## **Application by EPL 001 Ltd for Stonestreet Green Solar**

### **The Examining Authority's Second written questions and requests for information (ExQ2)**

**Issued on Tuesday 25 March 2025**

Note: Trips are 1-way

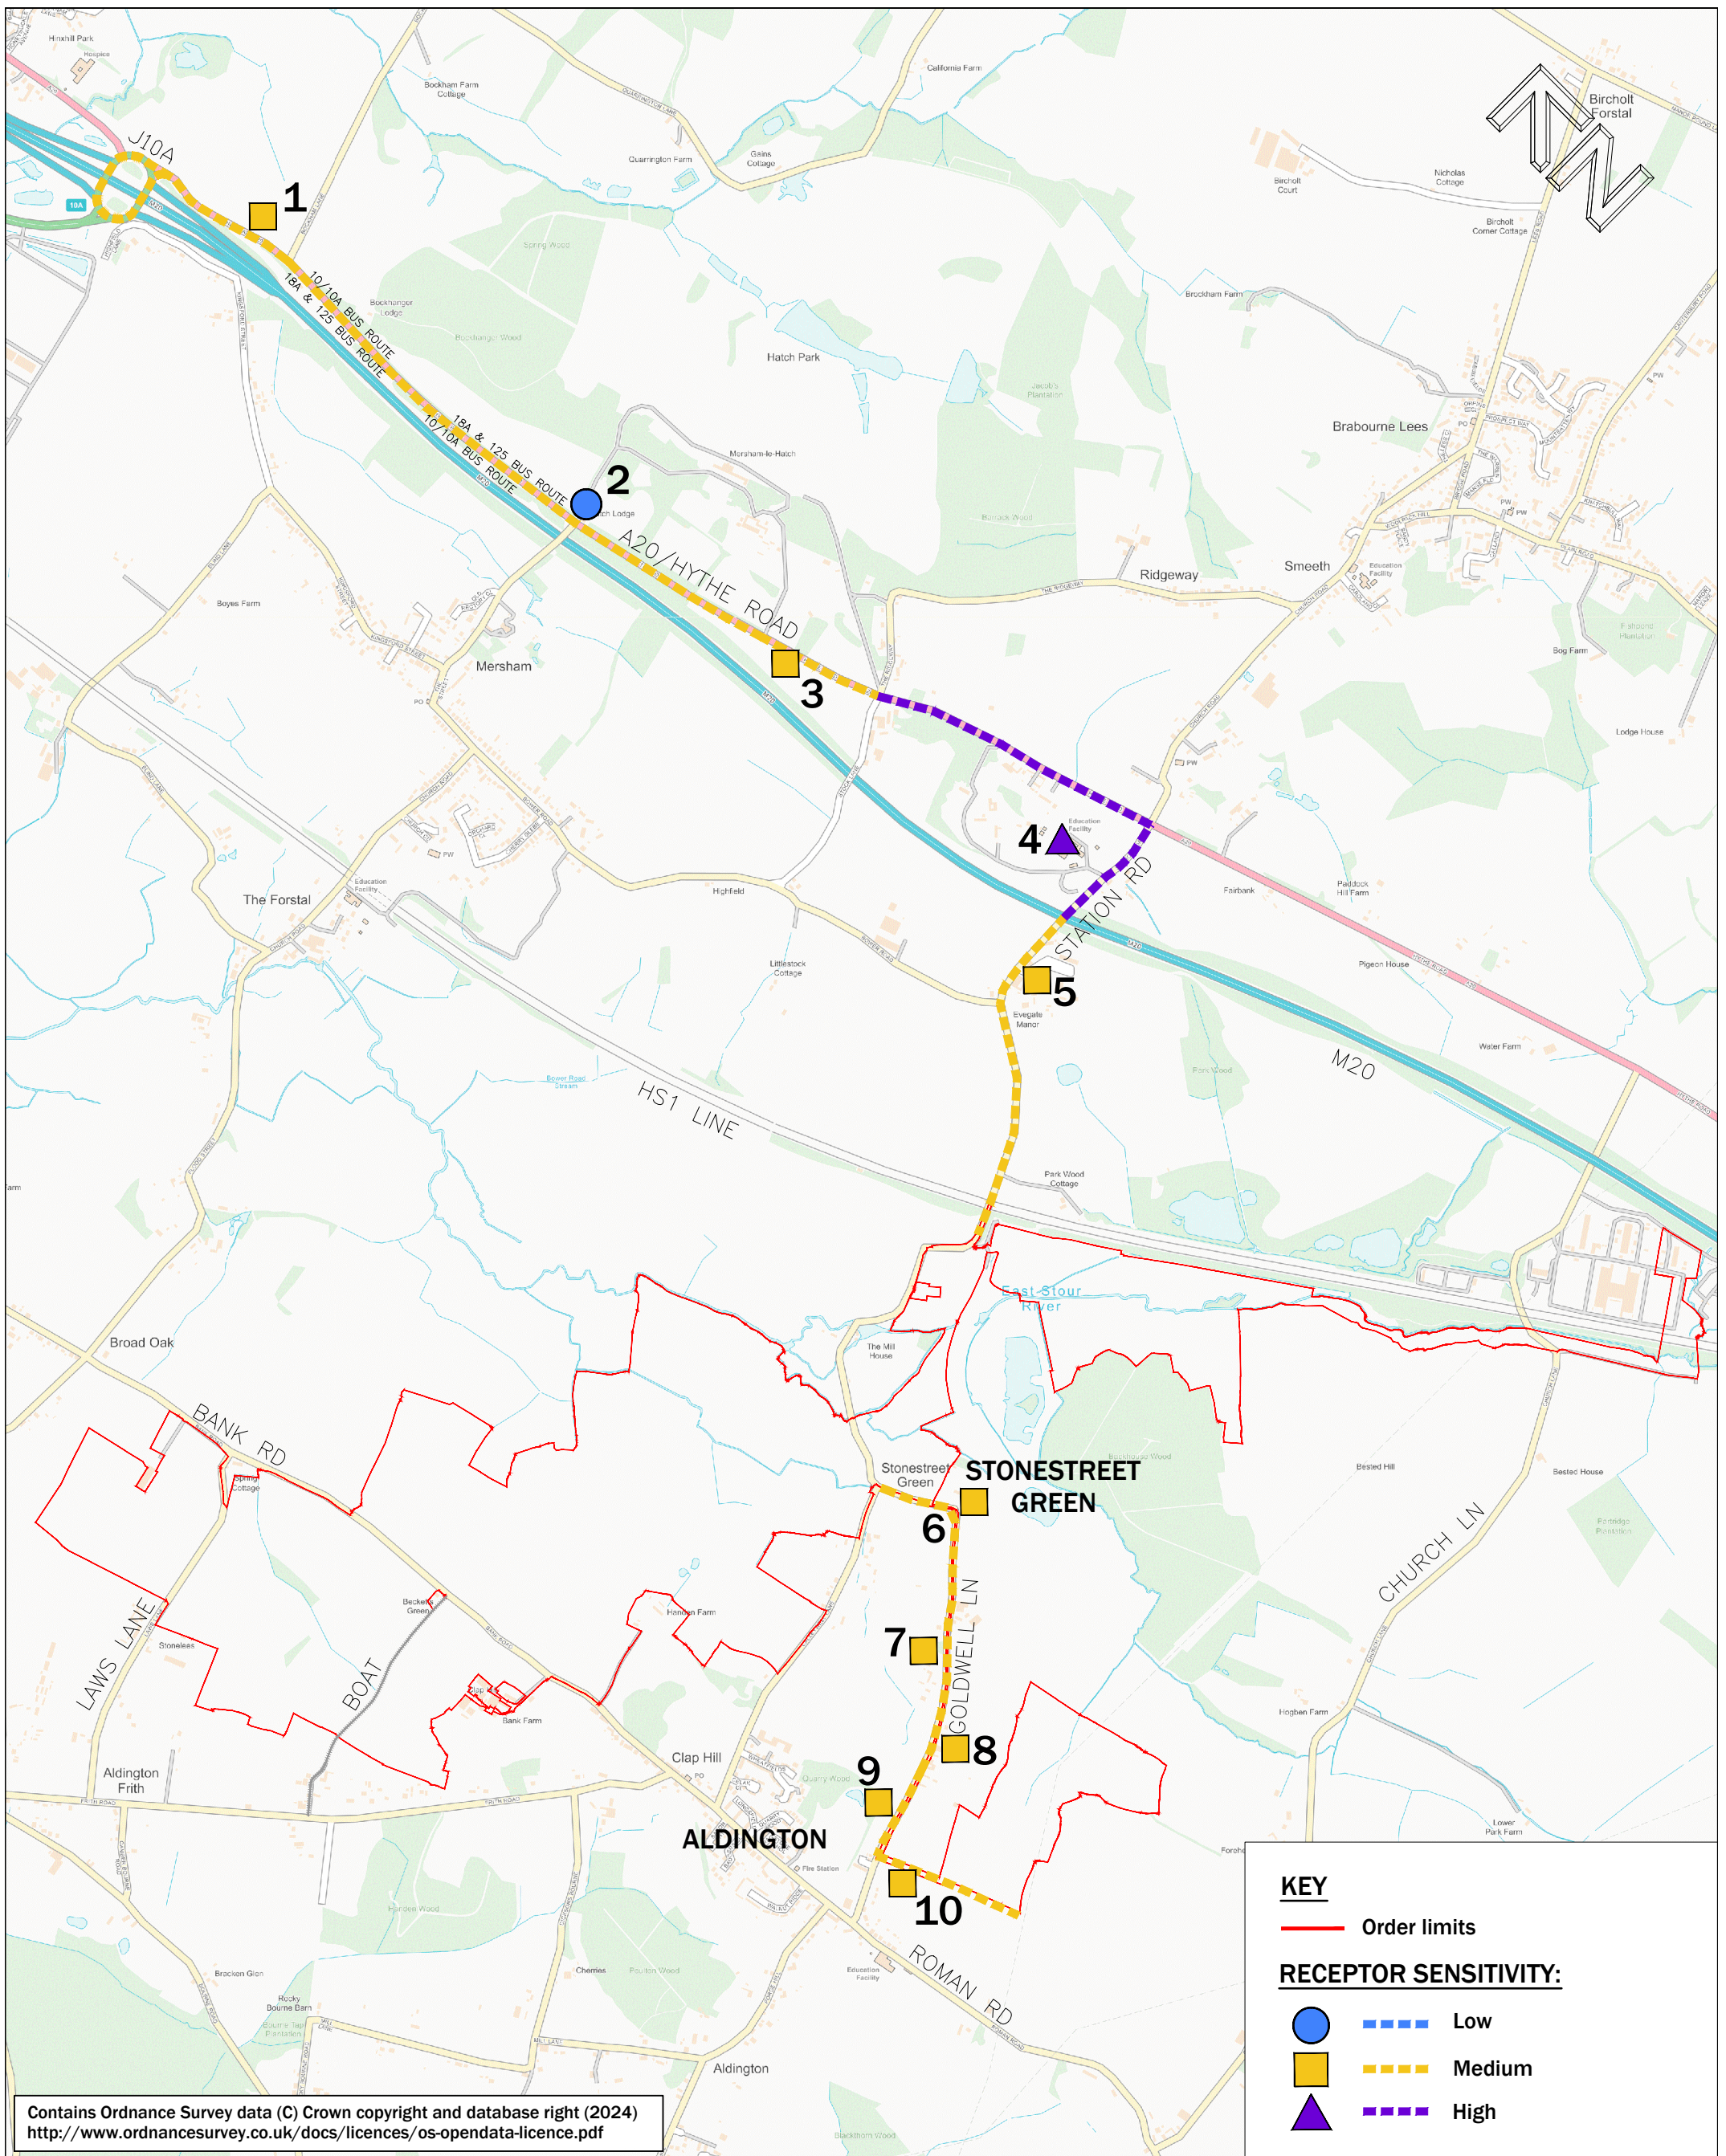
| ExQ2                        | Question to:                                 | Question:  |
|-----------------------------|--|--|
| Q5.0.2                      | ABC<br>KCC                                   | <b>Surveys - Written Submission from Applicant following ISH3 [REP4-030]</b><br><br>Action Point 2 in relation to survey results, the Applicant makes the following statement- "The results show that observations made during the Site visits that  |

| ExQ2                             | Question to:  | Question:   |
|----------------------------------|---------------|---|
|                                  |               | <p>the local PRoW network is relatively lightly used are confirmed by the survey data. This is not unexpected given that the PRoW network currently offers limited connectivity between settlements.”.</p> <p>Can the local authorities confirm that they agree with this assertion?</p>  |
